SEQUENTIAL TEST ADDENDUM - DEMOLITION OF EXISTING BUILDINGS AND REDEVELOPMENT FOR A BUILDERS MERCHANT WITH OUTSIDE STORAGE, A FOOD RETAIL STORE, ALONG WITH ACCESS, SERVICING, PARKING, BOUNDARY TREATMENT AND LANDSCAPING.

TRAVIS PERKINS PIER ROAD/NEW ROAD LITTLEHAMPTON

Thank you for forwarding the site investigation reports and Detailed Quantitative Risk Assessment (DQRA) for the above site. We have the following comments to make:

CLASS	Ltd UK GmbH				
ROLE	Per Road, Unterhempfen				
GENERAL ACTION	Expenditure Hole Location Plan				
STATUS	FOR INFORMATION		FILE		
SCALE	MTS	FILE DATE	SPENDING NUMBER		REASON
		02.09.2006	J-84093/2034

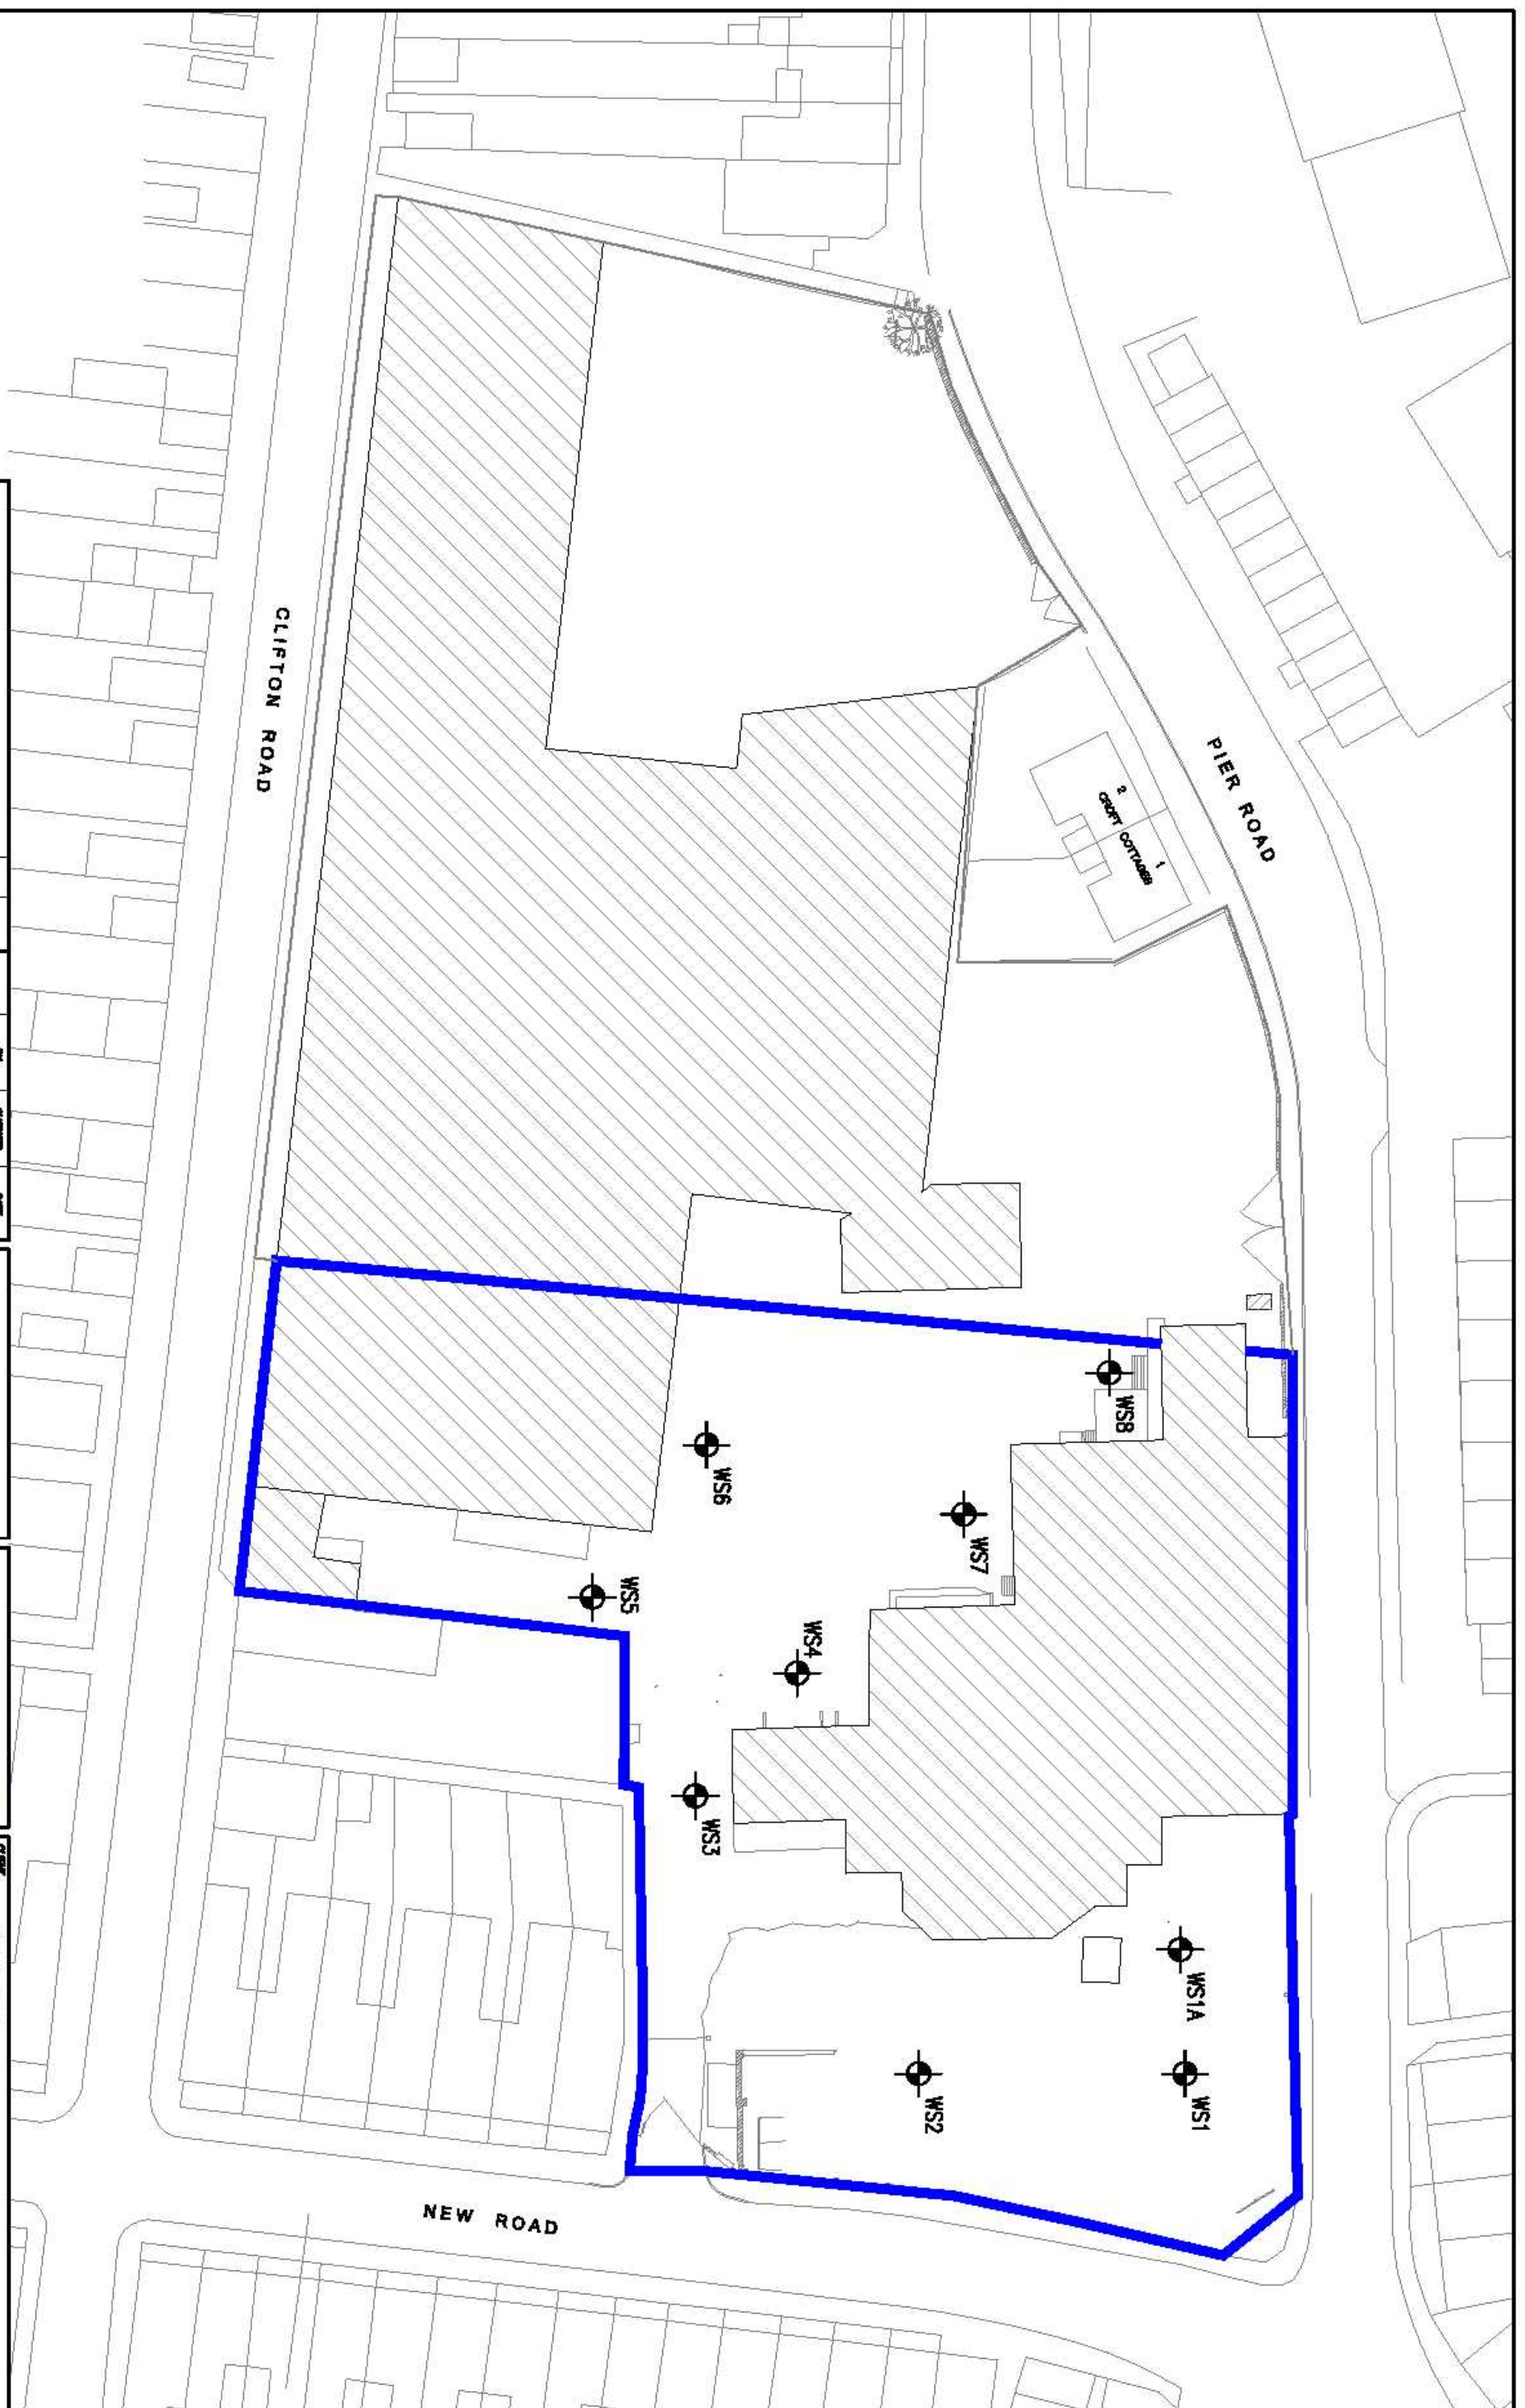
It is noted that the investigation on the north area of the site was limited in to the extent of the external areas only. The investigation undertaken was satisfactory however only a limited of samples were analysed for key contaminants of concern. It is noted that no soil samples in WS 1, 2 5, 6 & 8 were analysed for TPH fractions. Full characterisation around the tanks has not been undertaken. However the identified levels though show low levels of TPH contamination in the soils and groundwater.

The report has recommended additional investigations. We agree with this conclusion. This would be appropriate when the main building is being demolished.

- Additional groundwater monitoring of the existing window samples.
- Additional Investigations around the former tank
- Additional Investigations in the building areas after demolition
- The Controlled Waters DQRA needs to be updated in light of our comments above. In addition to this, if any of the investigation identifies higher levels of TPH fractions or Arsenic than found during the initial investigations, the DQRA needs to be rerun.
